**PLANNING DEPARTMENT
DEVELOPMENT SERVICES DIVISION
600 2nd Street NW, Ground Floor, 87102
P.O. Box 1293, Albuquerque, NM 87103
Office (505) 924-3946**

OFFICIAL NOTIFICATION OF DECISION

Project# PR-2023-008157
Application#
SD-2023-00175 – PRELIMINARY/FINAL PLAT

LOT 1-B, FREEWAY-OLD TOWN, LIMITED
zoned **NR-LM**, located at **1810 BELLAMAH**
AVE NW between 18th ST NW AND 20th ST
NW containing approximately **4.2862** acre(s).
(J-13)

EXHIBIT A – EXISTING RETENTION POND LOCATED AT THE EASTERN EDGE OF LOT 1-B, FREEWAY-OLD TOWN, LIMITED

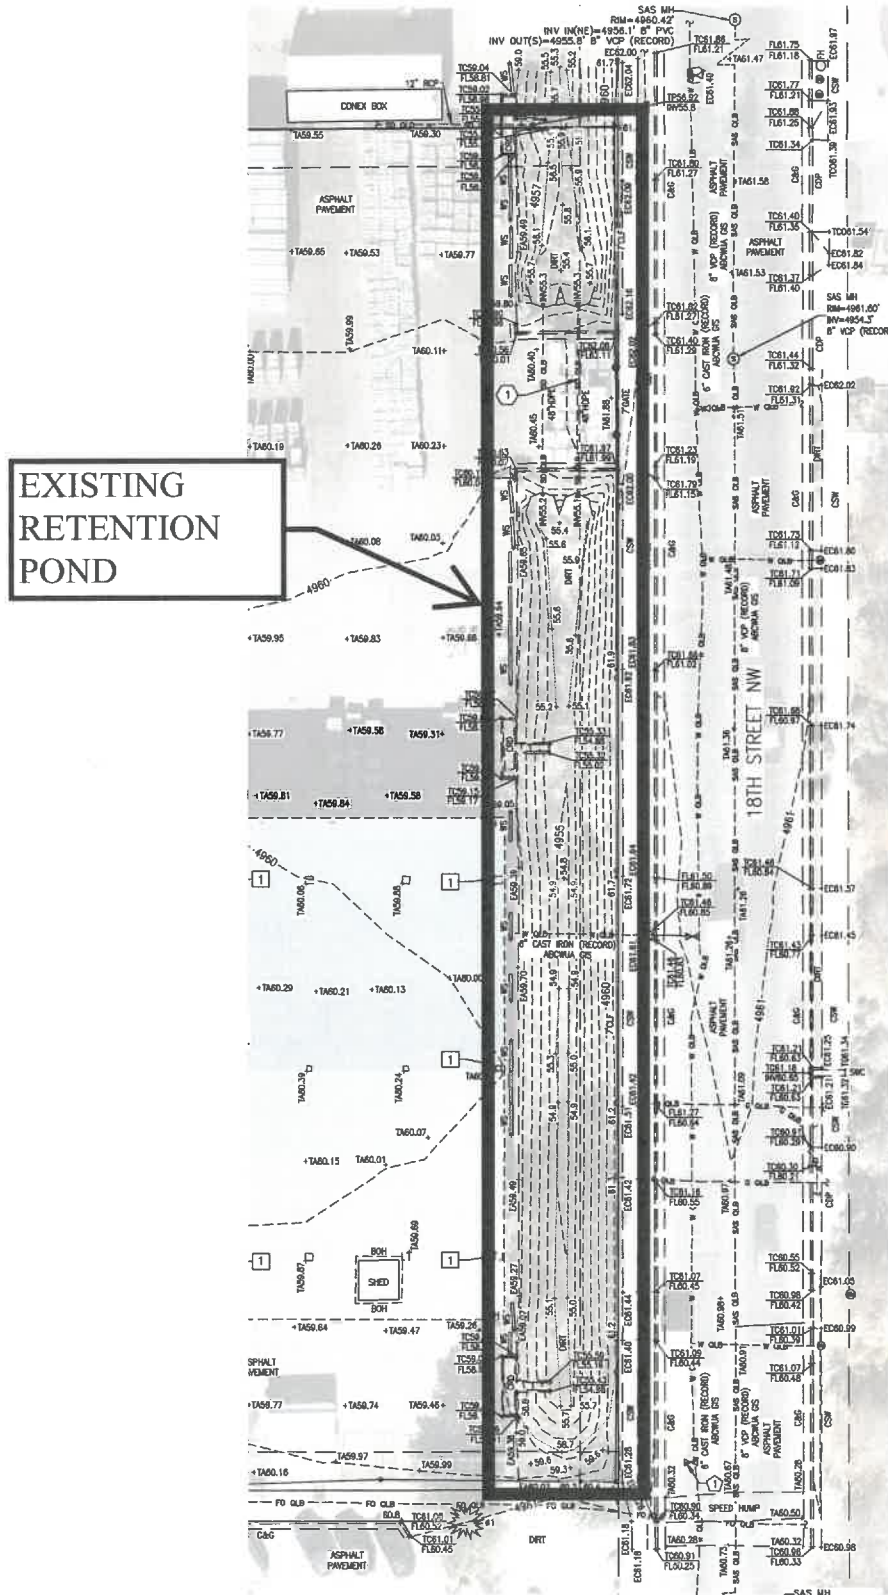
- a. A note added to the plat pertaining to the availability of water and sewer as discussed.
- b. Recorded Infrastructure Improvements Agreement (IIA).
- c. Project and application numbers must be added to the plat.
- d. AGIS DXF file.
- e. A drainage convenient will be created on the parcel covering the existing drainage pond as a condition of final plat approval.
